Middleton-on-Sea Association

**25 SEA WAY, MIDDLETON-ON-SEA
PLANNING APPLICATION M/41/18/HH**

The purpose of this letter is to notify you of the objections of the Management Committee of this Association, and many residents, to that development.

REAR ELEVATION

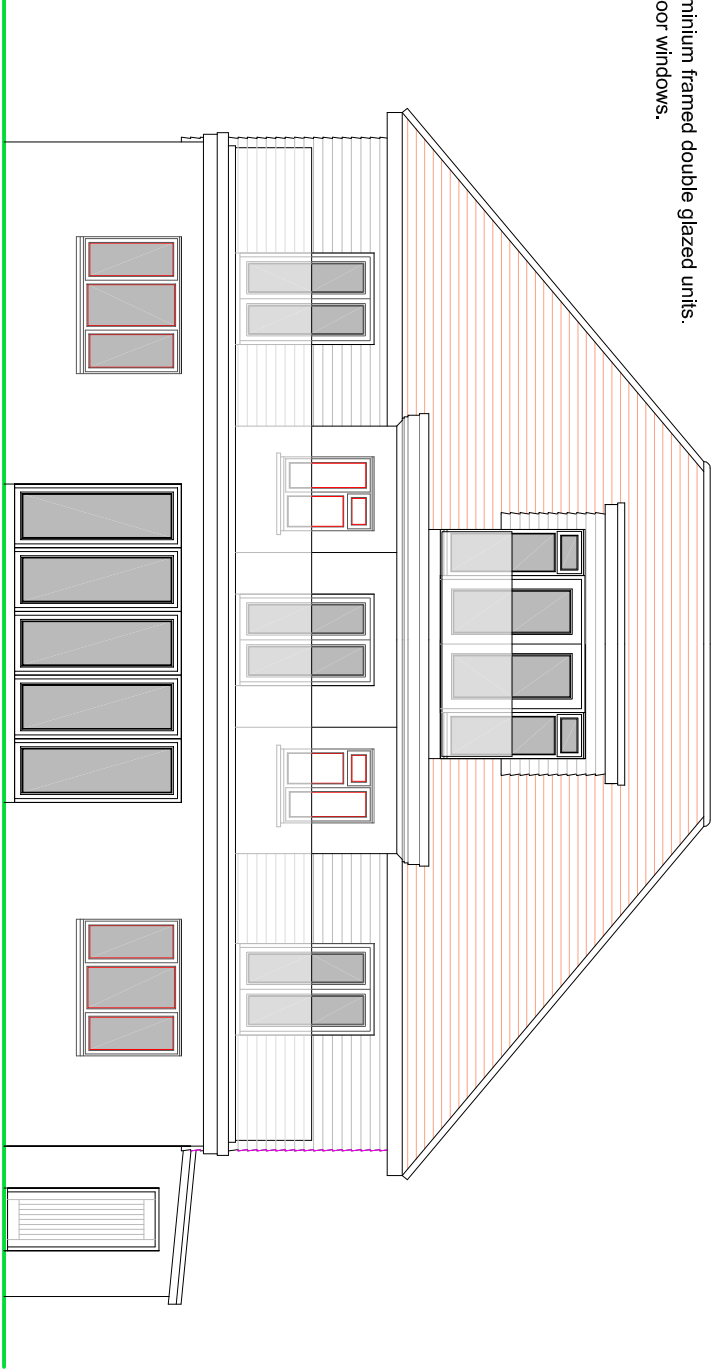
Effectively, the property becomes three storeys – three floors – with the third floor readily apparent in drawings of the rear (south) elevation.
